The Planning Inspectorate

Application by Gatwick Airport Limited for an Order Granting Development Consent for the Gatwick Airport Northern Runway Project

Request for further information

Title
**Surface Access Highways Plans
General Scheme Outline
APFP Regulations 5(2)(o)
Sheet 2**

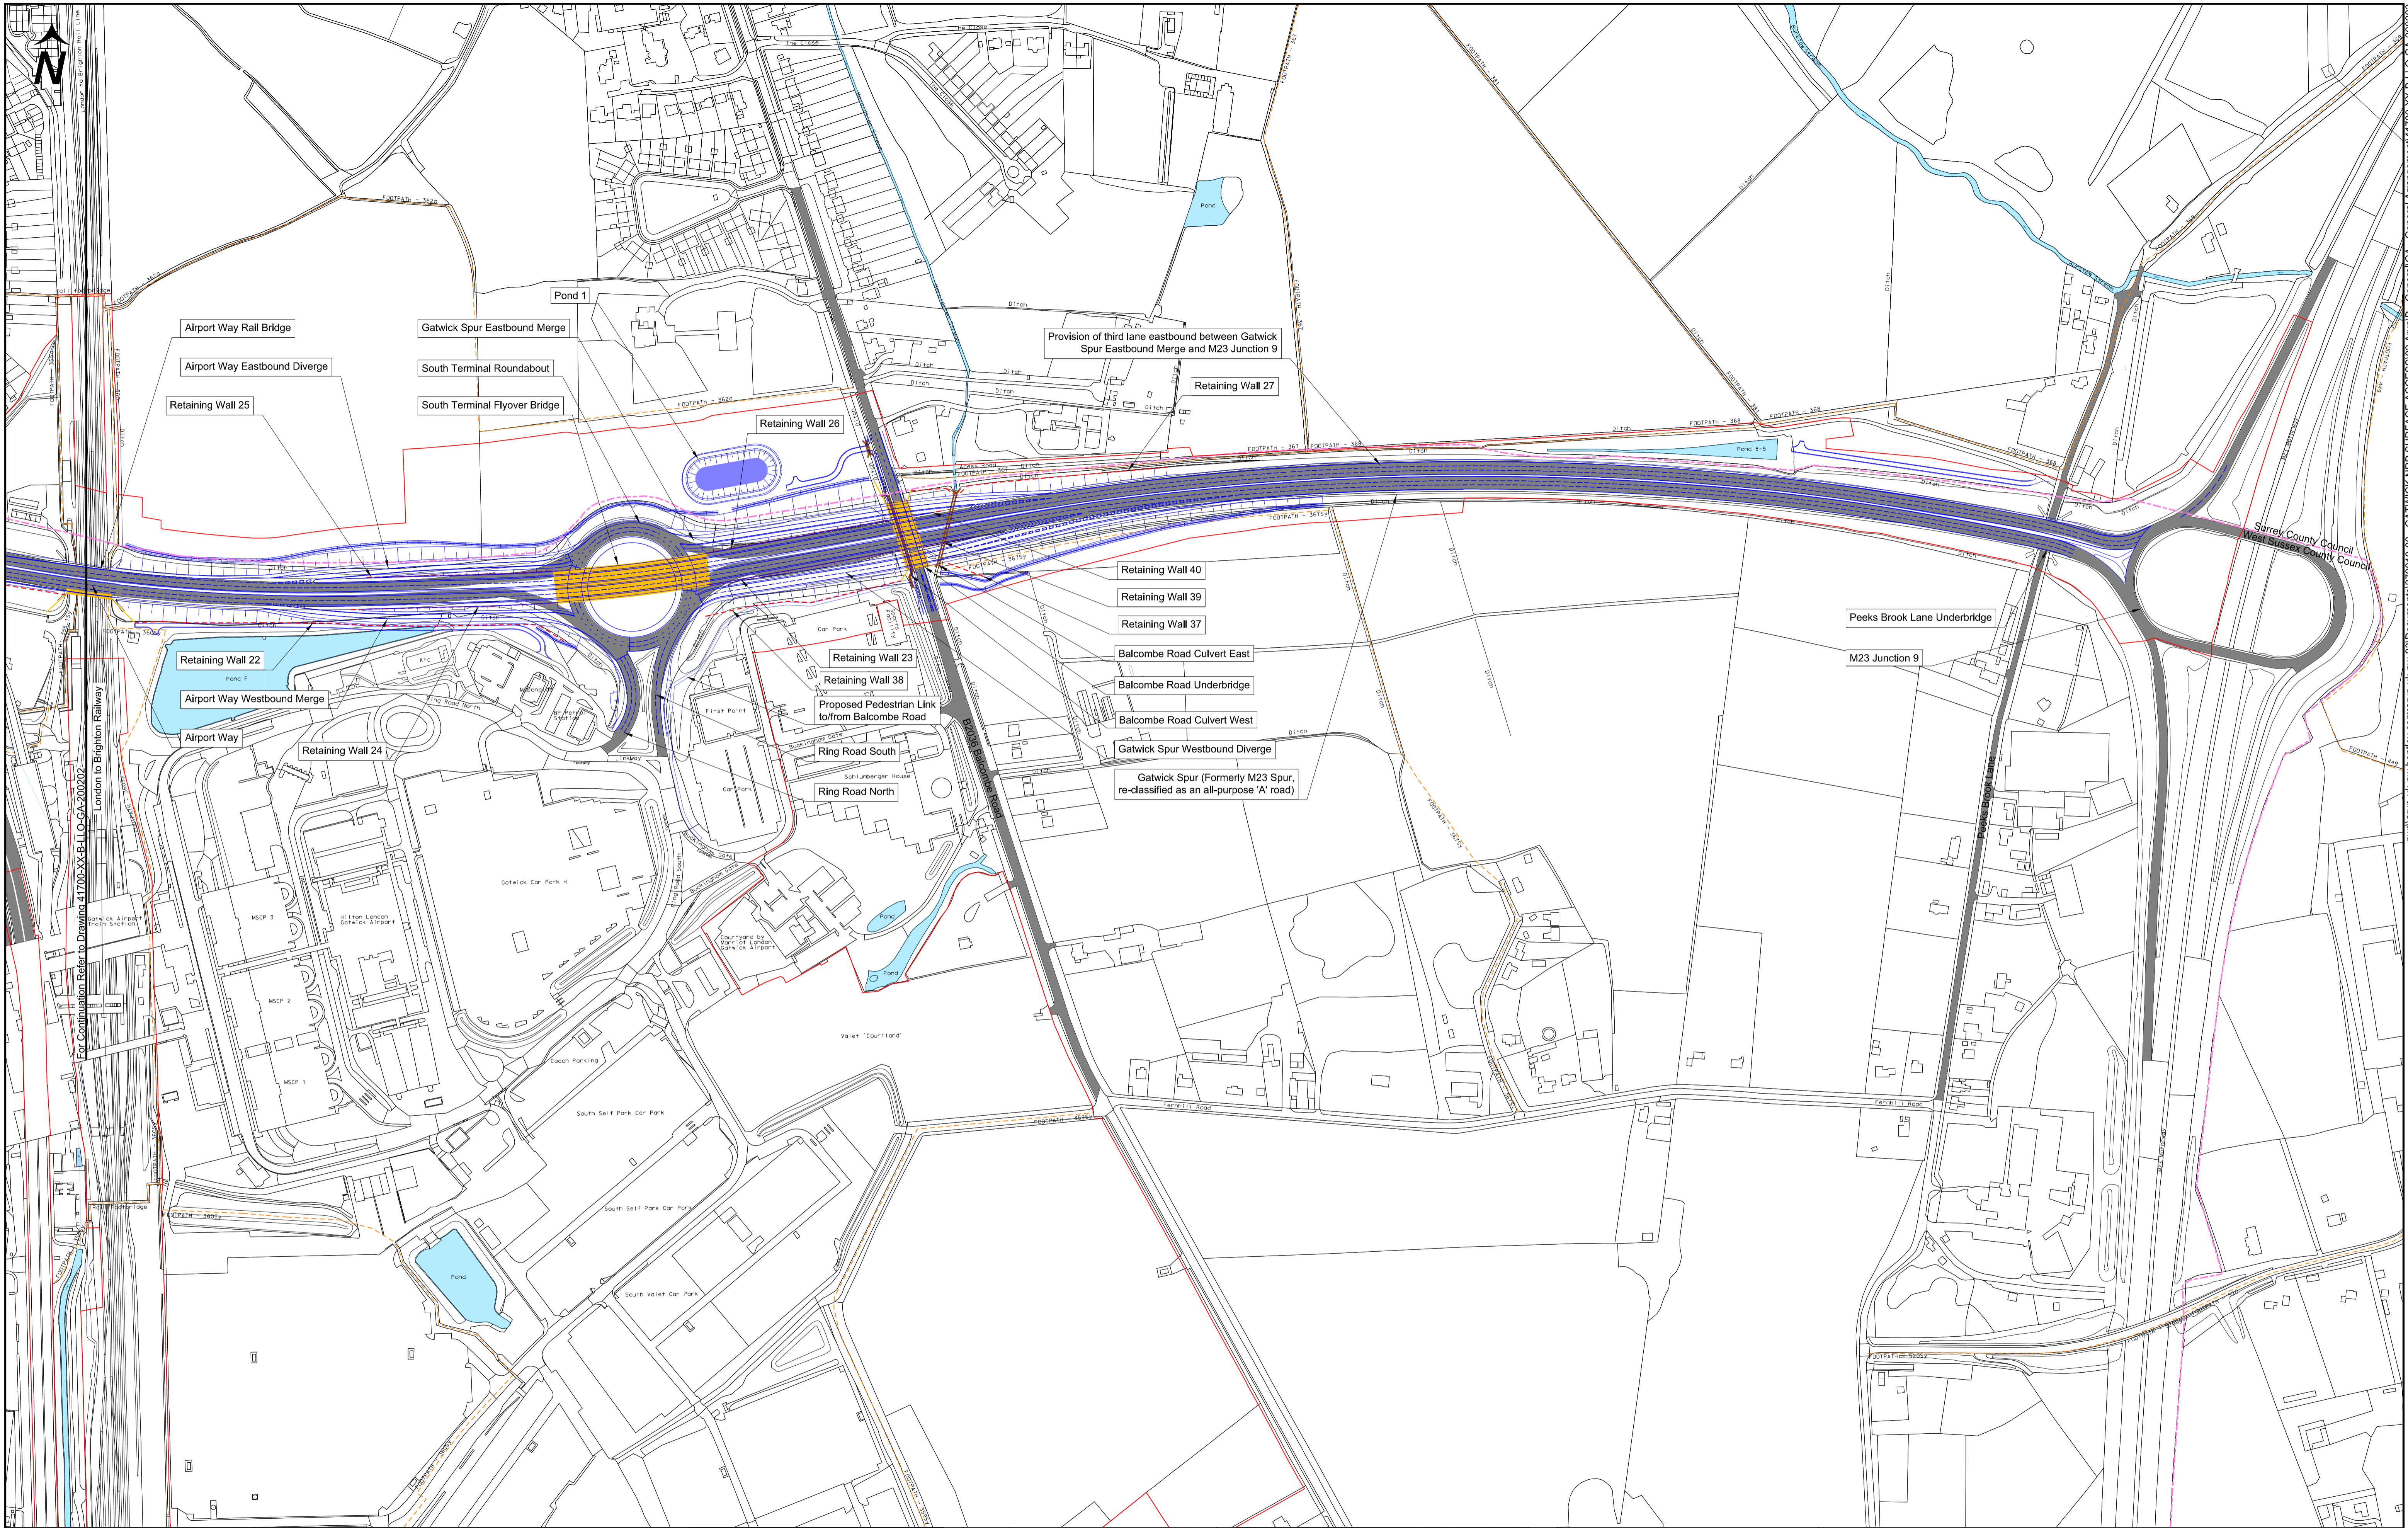
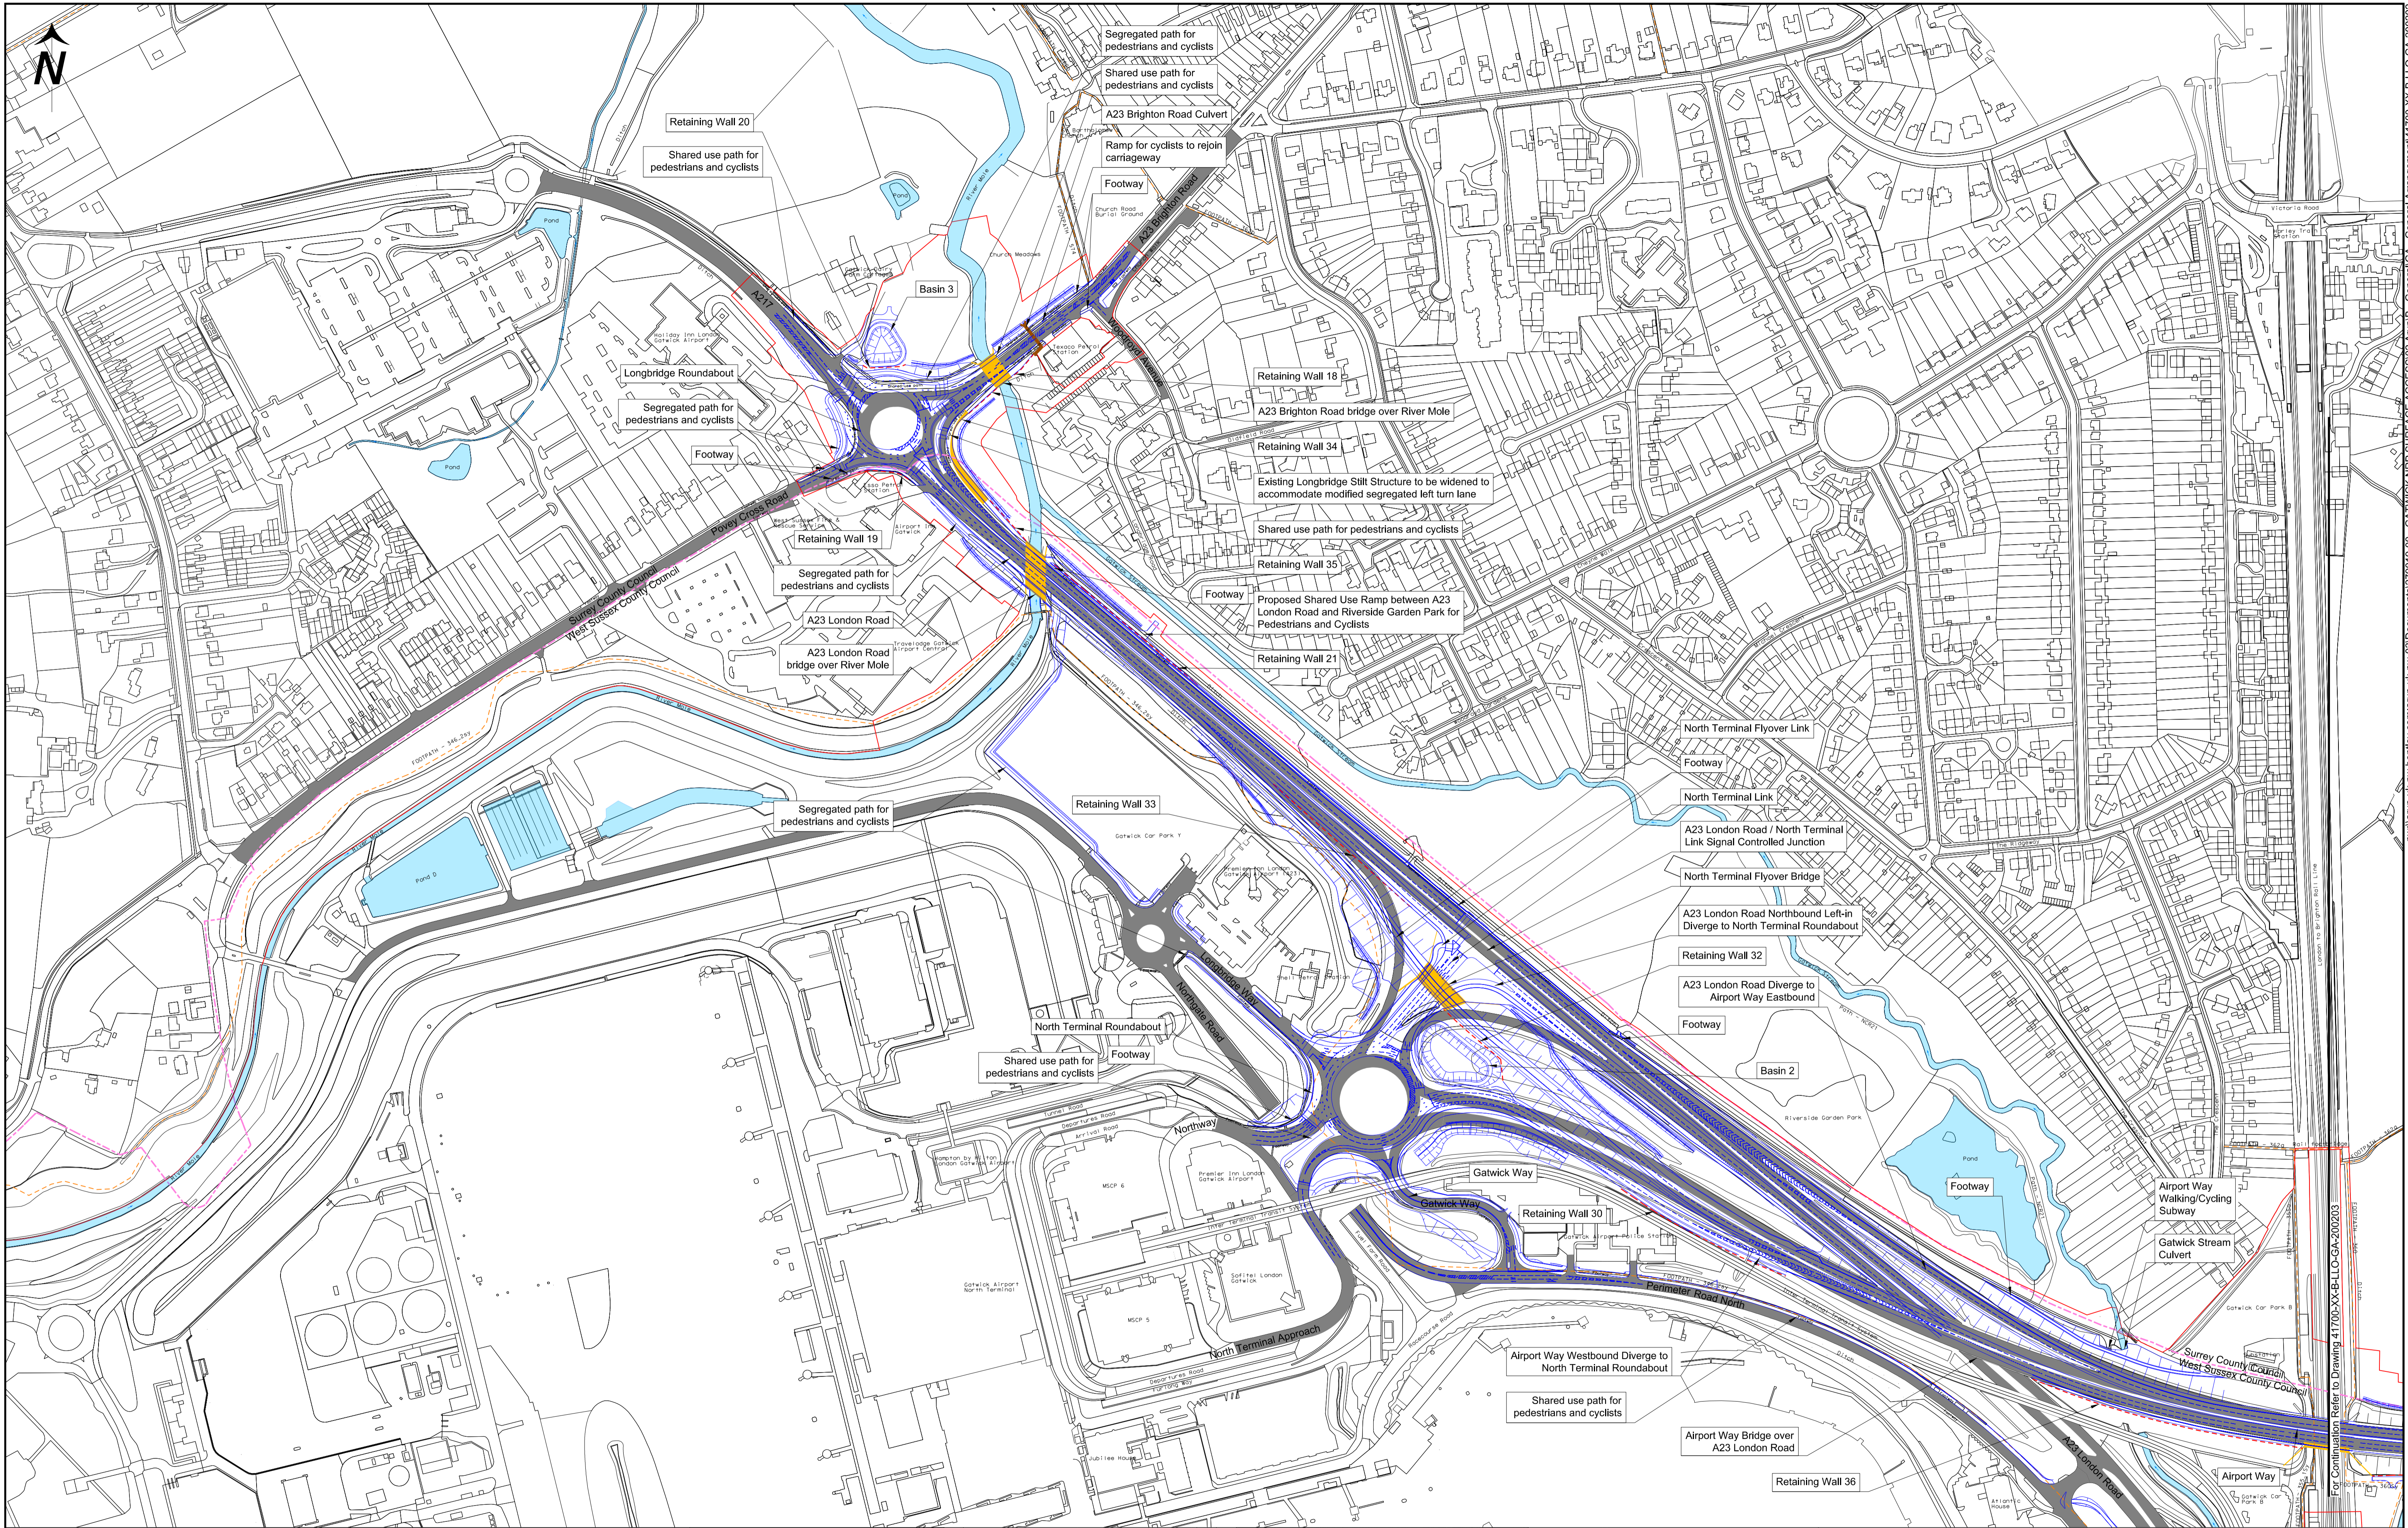
New Highway Layout Outline Plans are required to assist in the interpretation of the proposed scheme and its elements within the existing topography. The ExA requests such plans show the following in different colours:

- All existing topography in black and annotated as to identifiable features.
- Existing roads and footpaths hatched or shaded to enable identification within proposed outlines and any shading.
- Order Limits.
- Outline of proposed roads, active travel routes and extents of cutting and embankments.
- Light shading of proposed bridges/ viaducts.
- Light shading of proposed culverts/ tunnels.
- Any retaining walls.
